Re-consult Response to Planning Application

From: Arun District Council Greenspace
Date: 14/01/2021

Application ref: F/4/20/OUT Plan App with EIA

Location: Land at Ford Airfield Ford, West Sussex

FIGURE 5. ILLUSTRATIVE MASTERPLAN

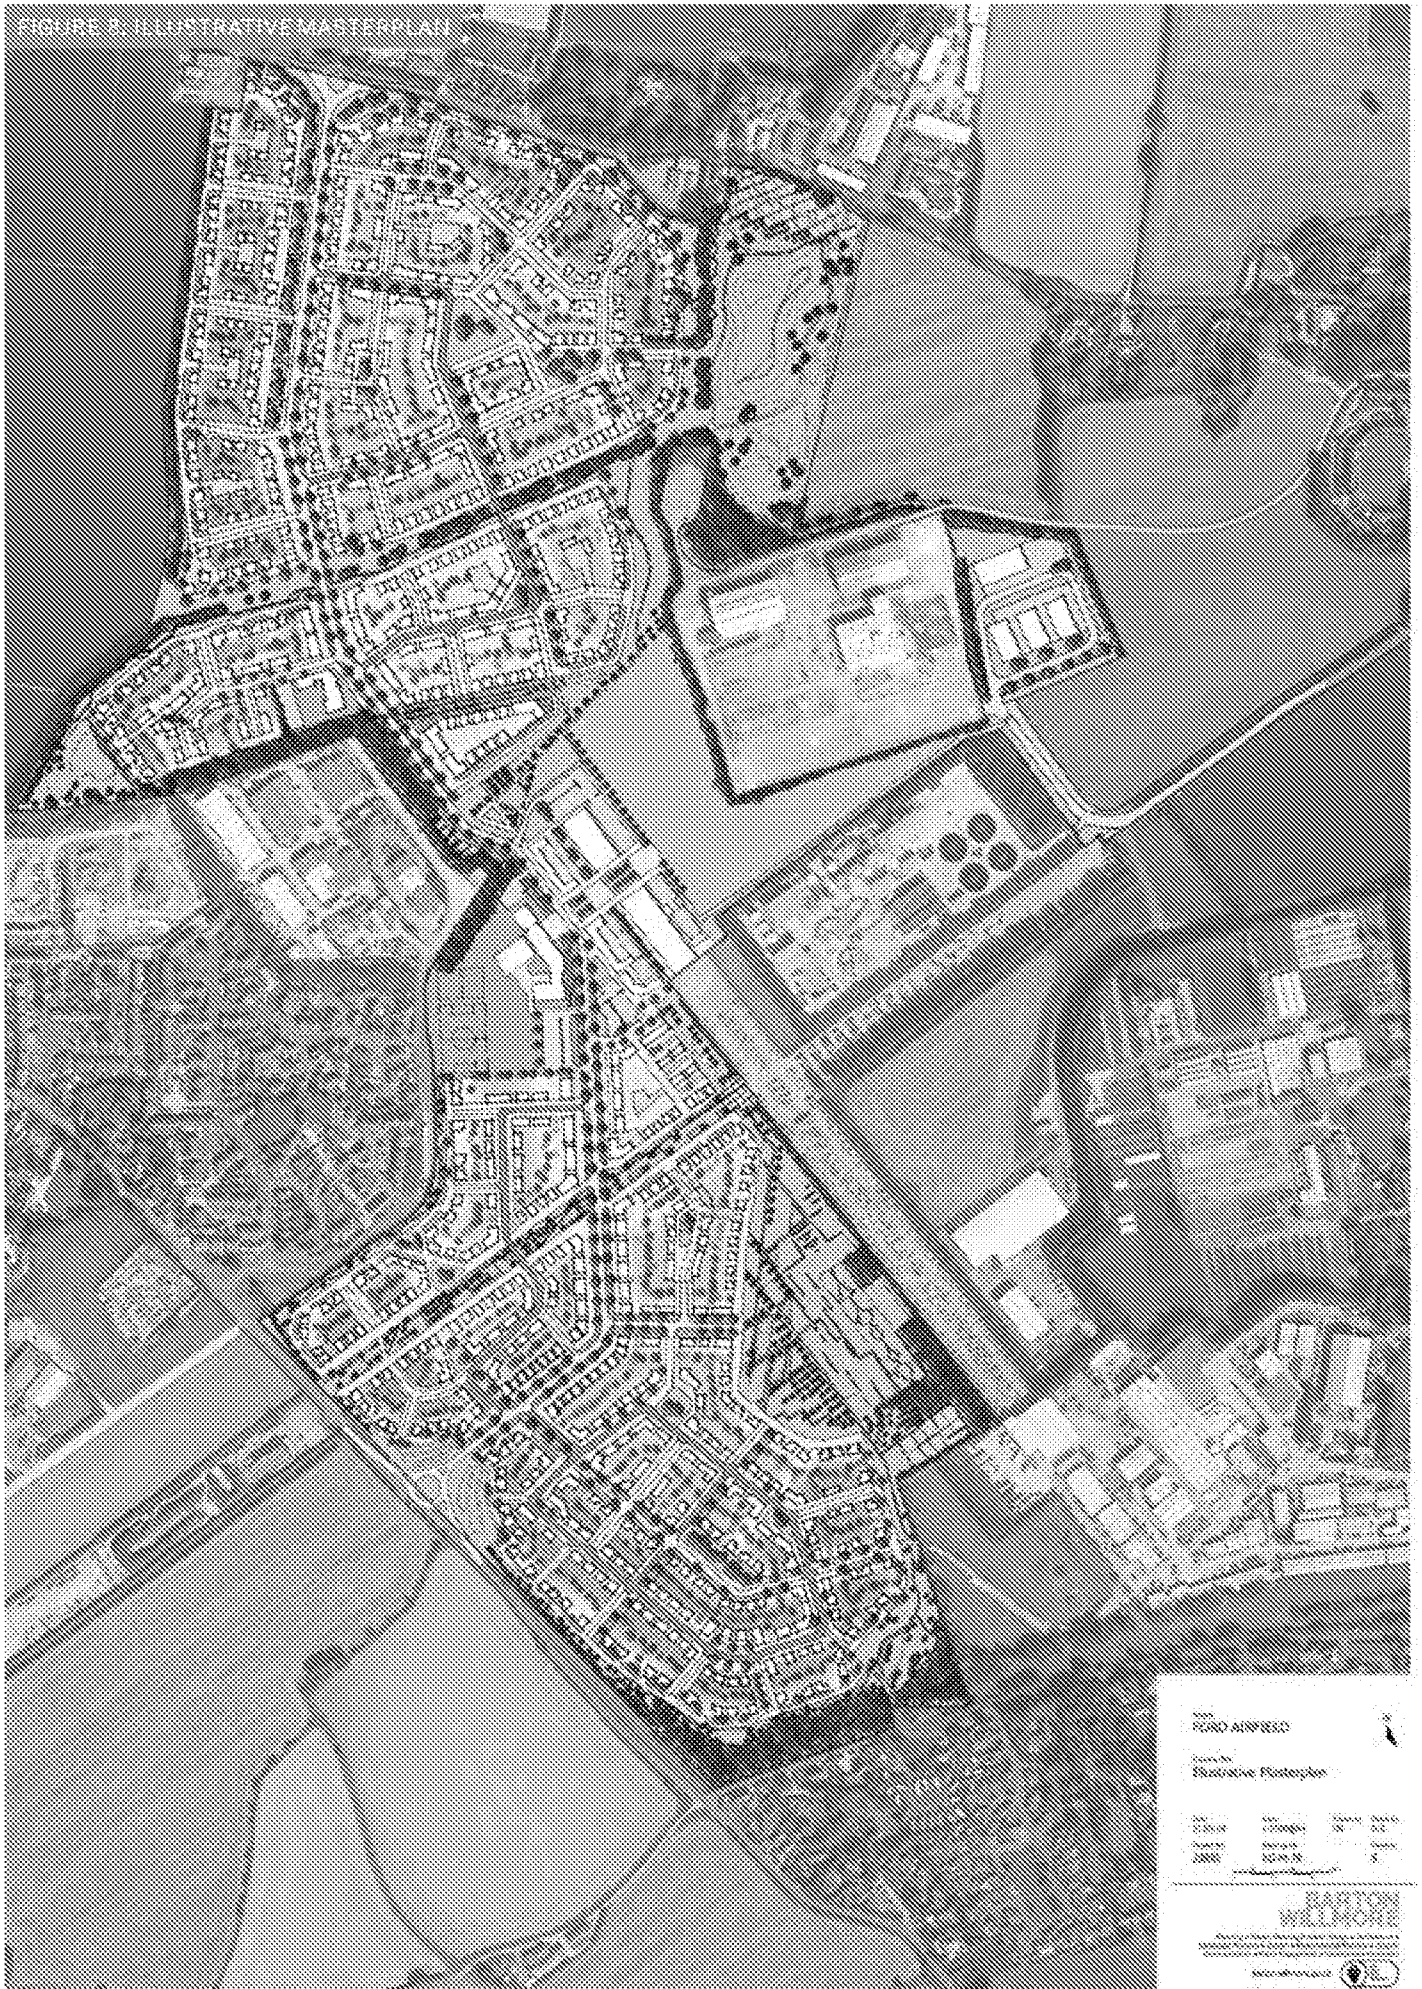
The illustrative masterplan 78s has indicated the retention of existing sports facilities and the provision of land of 3.23Ha sufficient to accommodate 2 full size adult football pitches. Further consultation will be required regarding this proposed provision and further for related changing facilities and associated carparking considerations.

Shown allotment provision will also require accessibility by car users and associated parking for these.

FIGURE 12: ILLUSTRATIVE LANDSCAPE MASTERPLAN

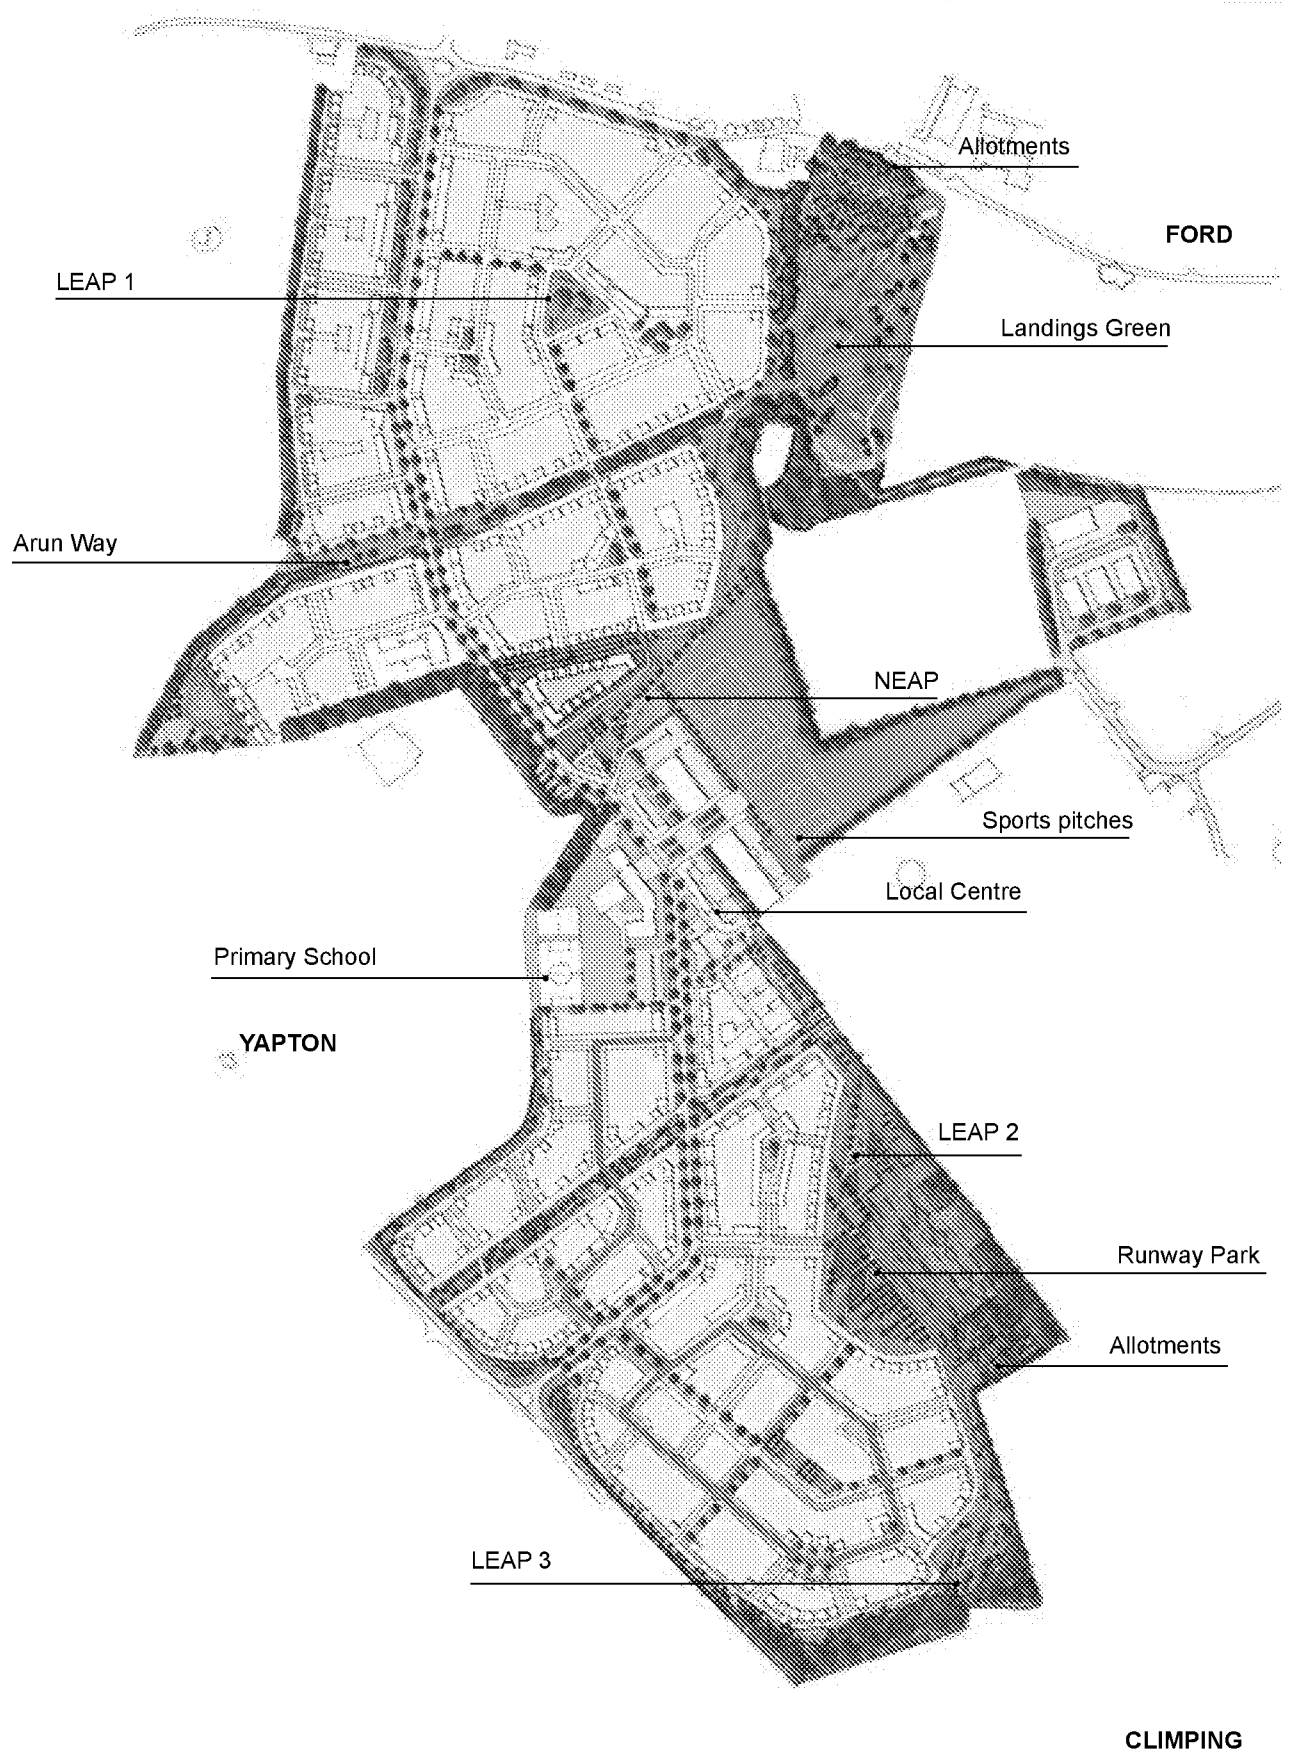
Green and Blue infrastructure parameter plan 121 J indicates most of the green POS to the east of the development site much of which fringes the adjoining existing commercial/industrial works. These areas need to be considered within good design principles, not only for convenience of avoiding for example 'odour zones'.

Greening will be required also within the plot areas, which would appear to be particularly devoid as shown. Greening throughout the development must be incorporated, creating a sense of place, connecting green corridors and softening what otherwise is shown as hard looking street scenes. We would want to see the inclusion of outward facing plots fronting greens and connectivity of these.
